# CLOVERLEAF SUBDIVISION

## PRELIMINARY PLAN

DATE: 6/1/2020  
PROJECT MGR: A. BARLOW  
PREPARED BY: B. SWENSON

DATE	BY	DESCRIPTION
9/11/2020	JBS	PER COUNTY COMMENTS

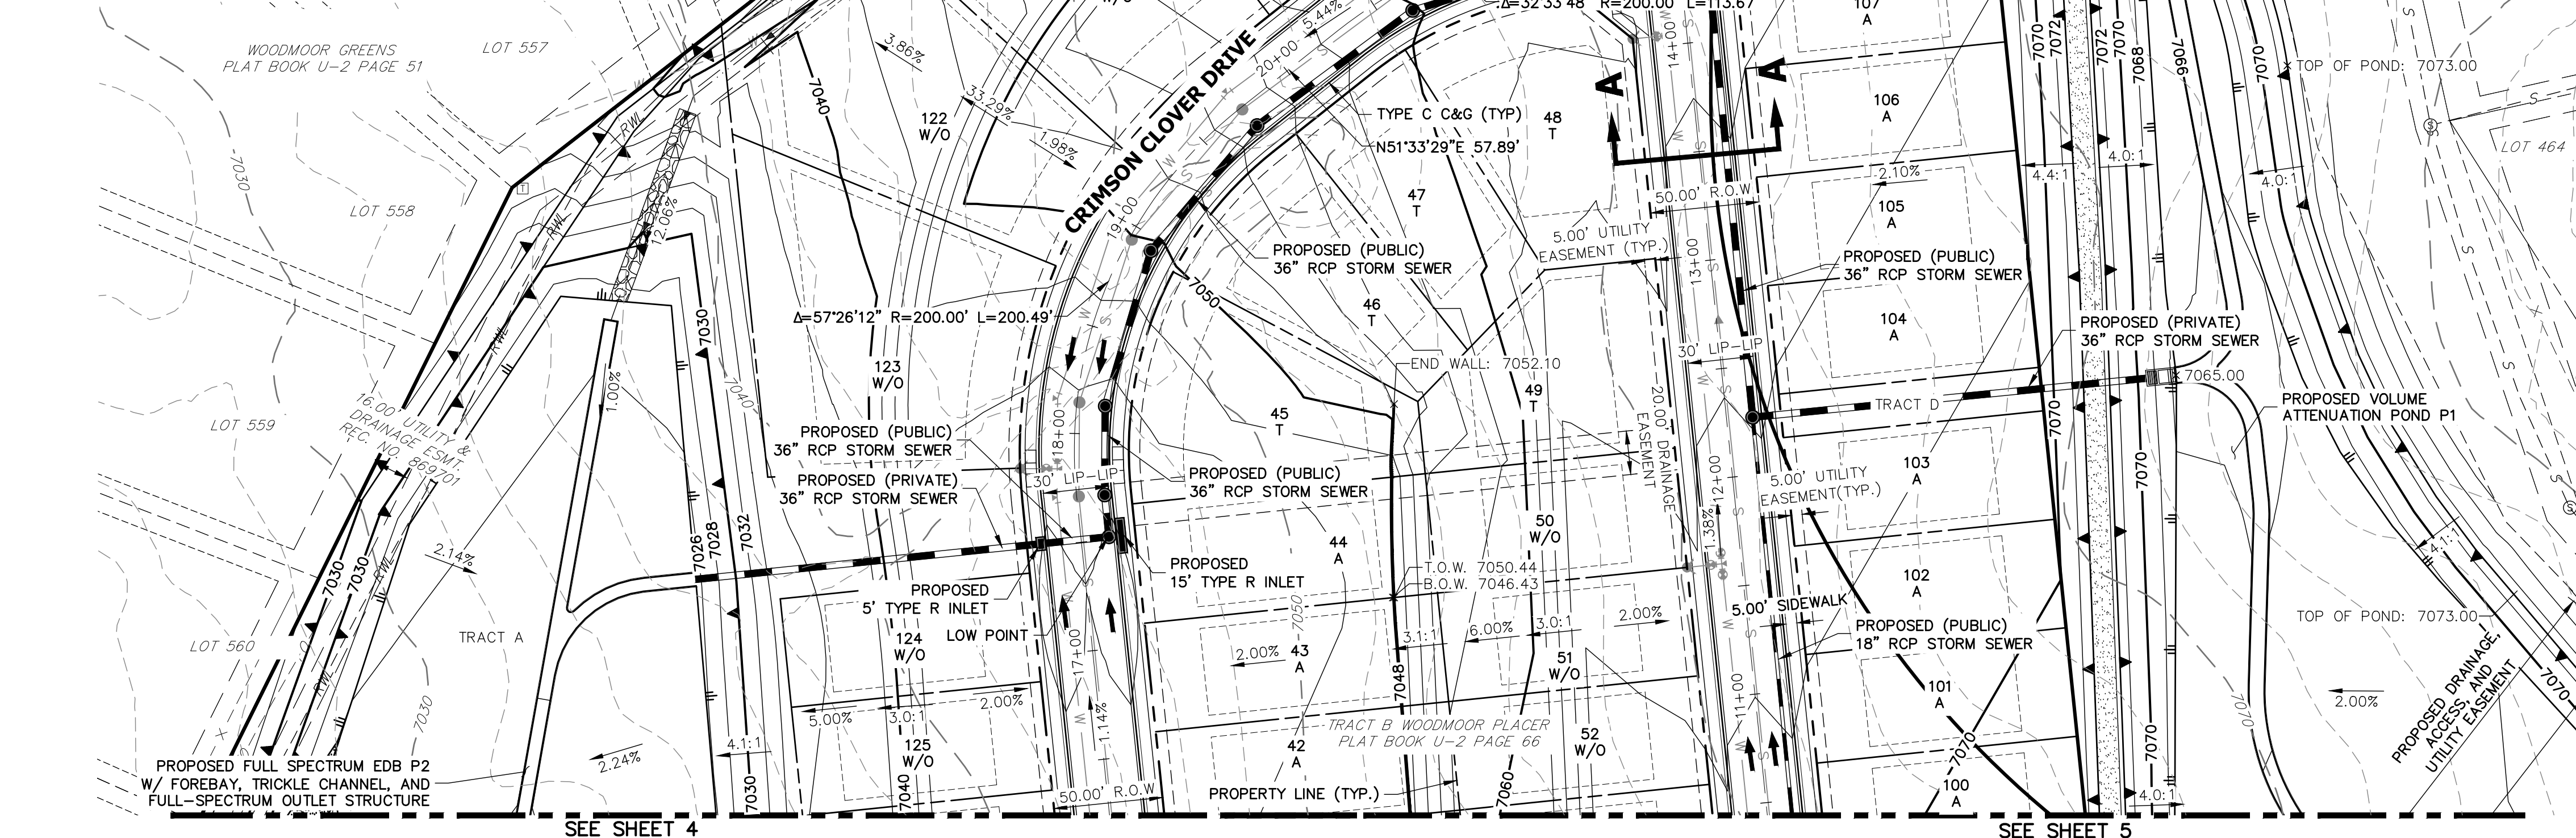
Update cross section to match the grading. Per swale note 1 ex property line and ex grade callout should be on the right side of the typical section.

Update typical cross section detail

Update to show the maintenance road prior to connecting to ex. grade.

Identify retaining wall greater than 4' in height will require building permit.

## ISOLATED LOTS PRELIMINARY GRADING & UTILITY PLAN

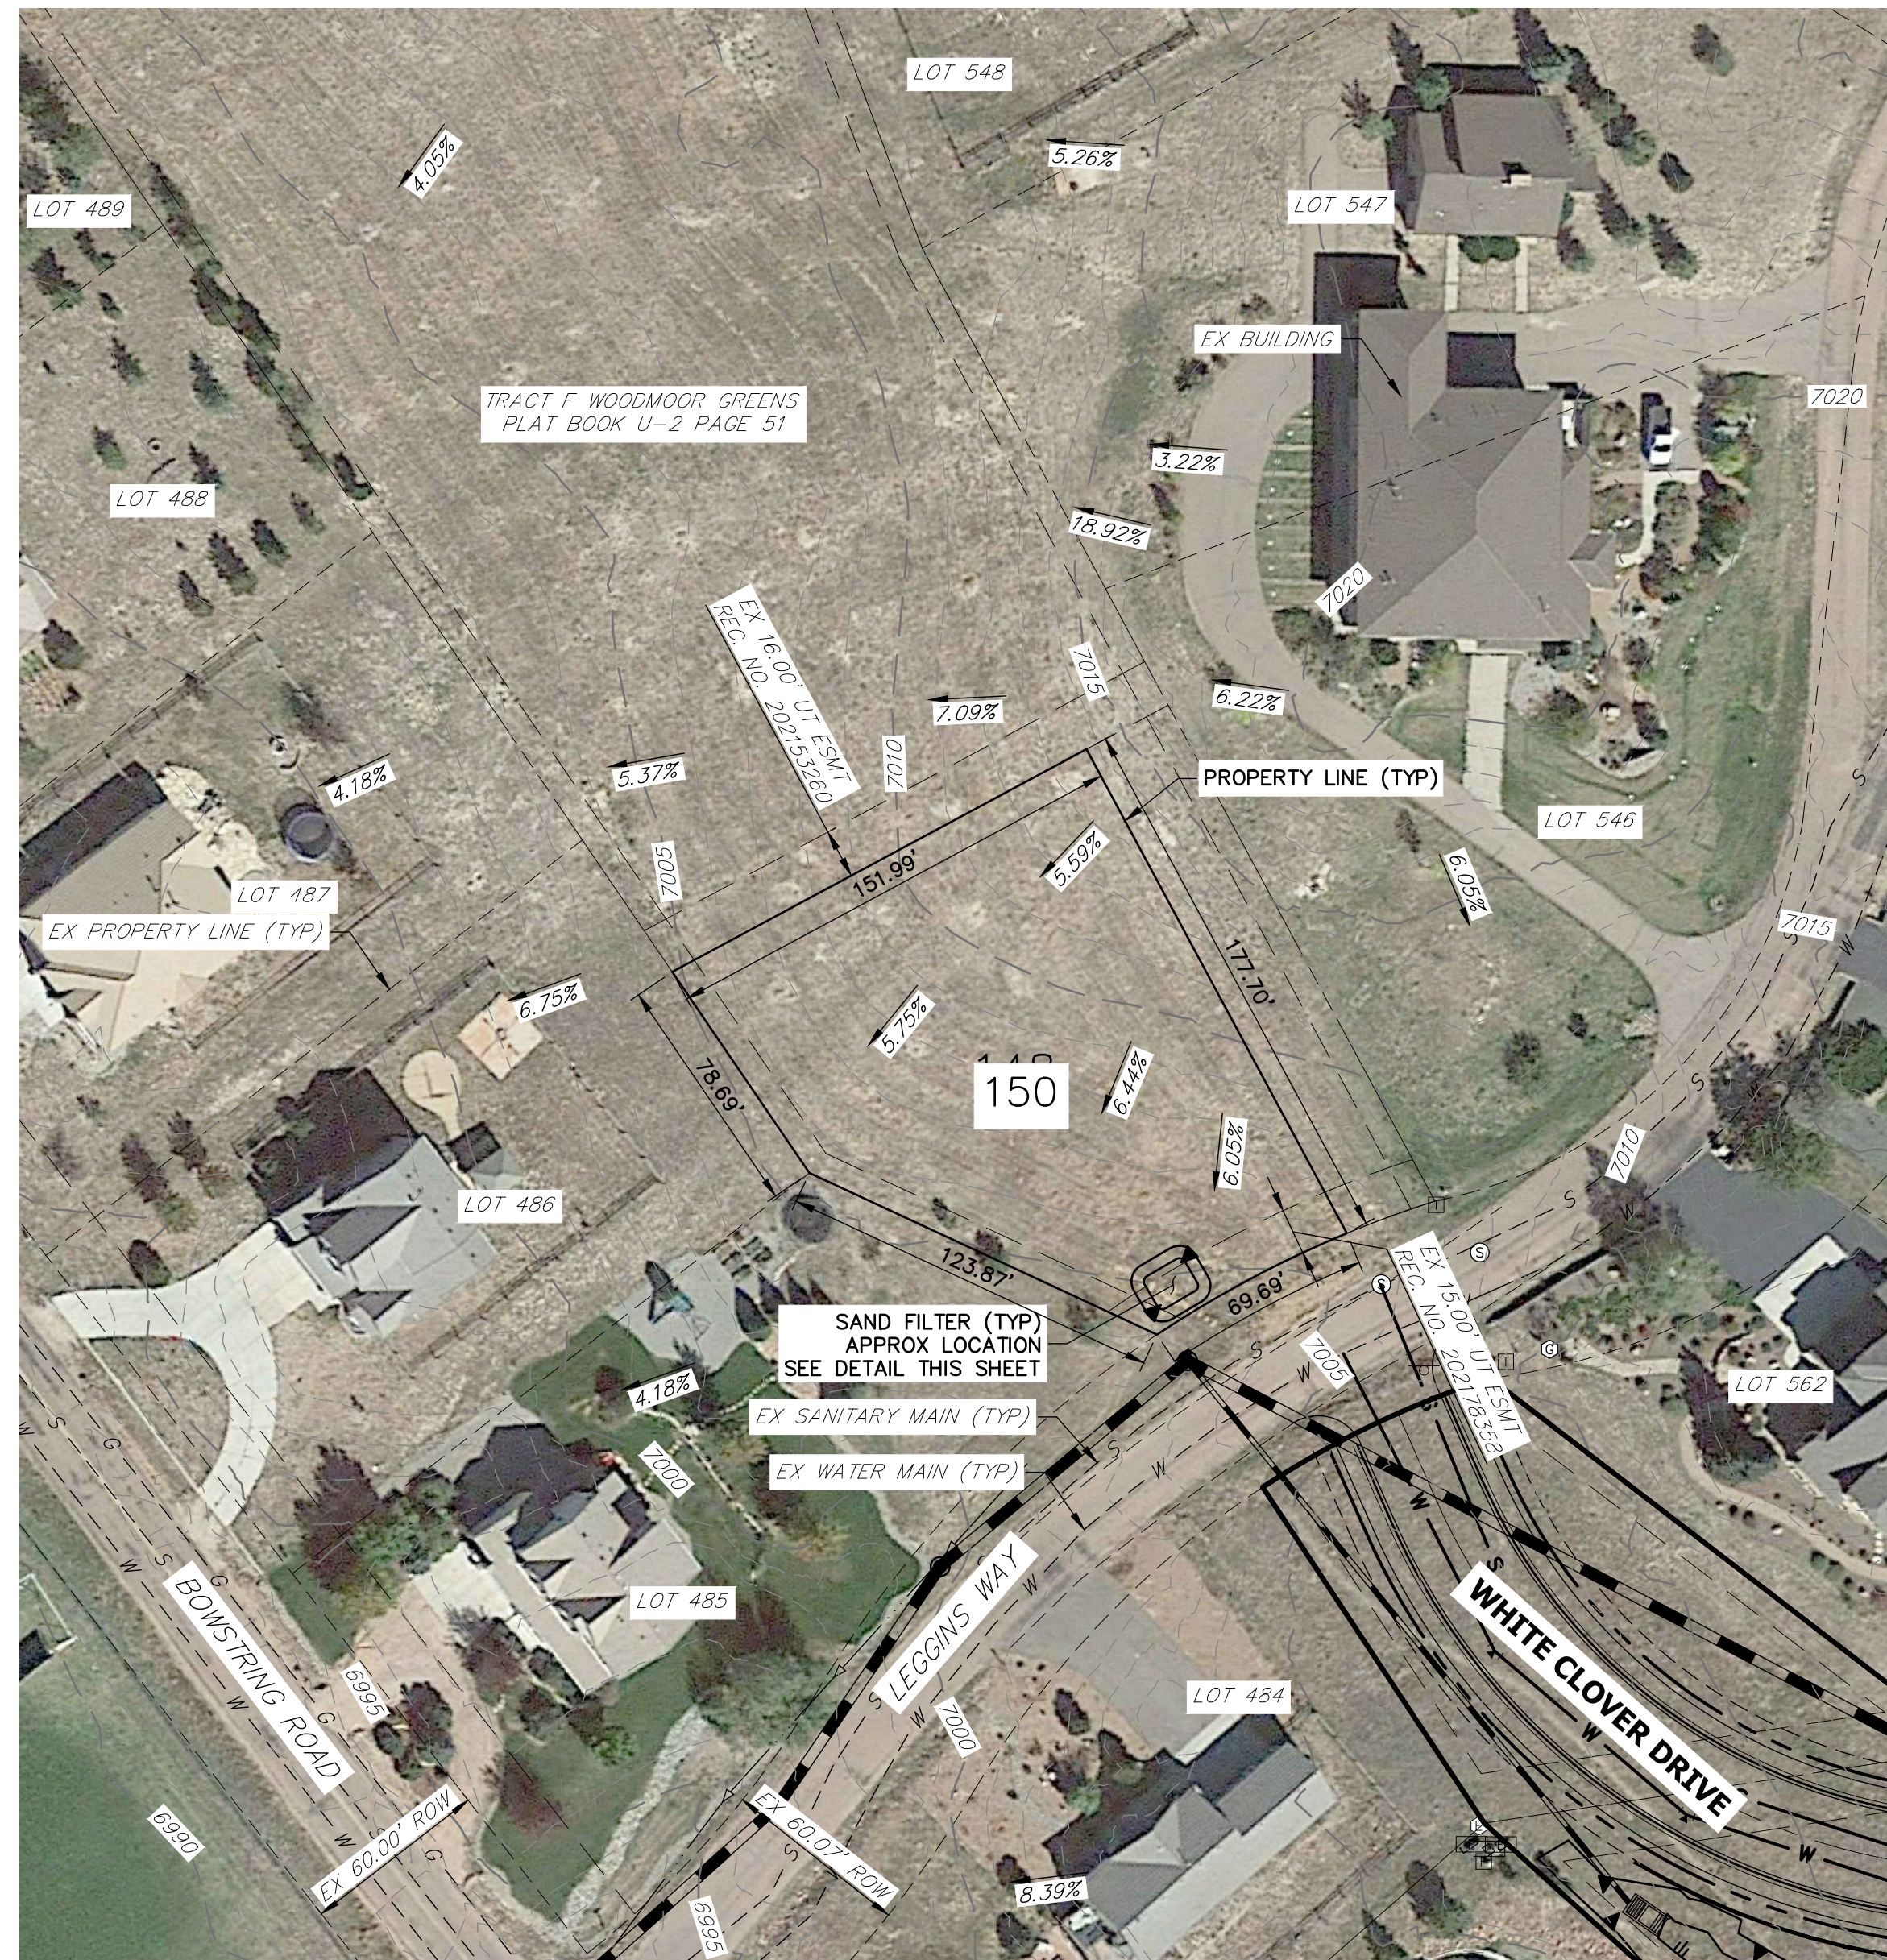
Show sight distance triangle.  
Coordinate with traffic engineer. See redline comment on pg 21 of the traffic study.
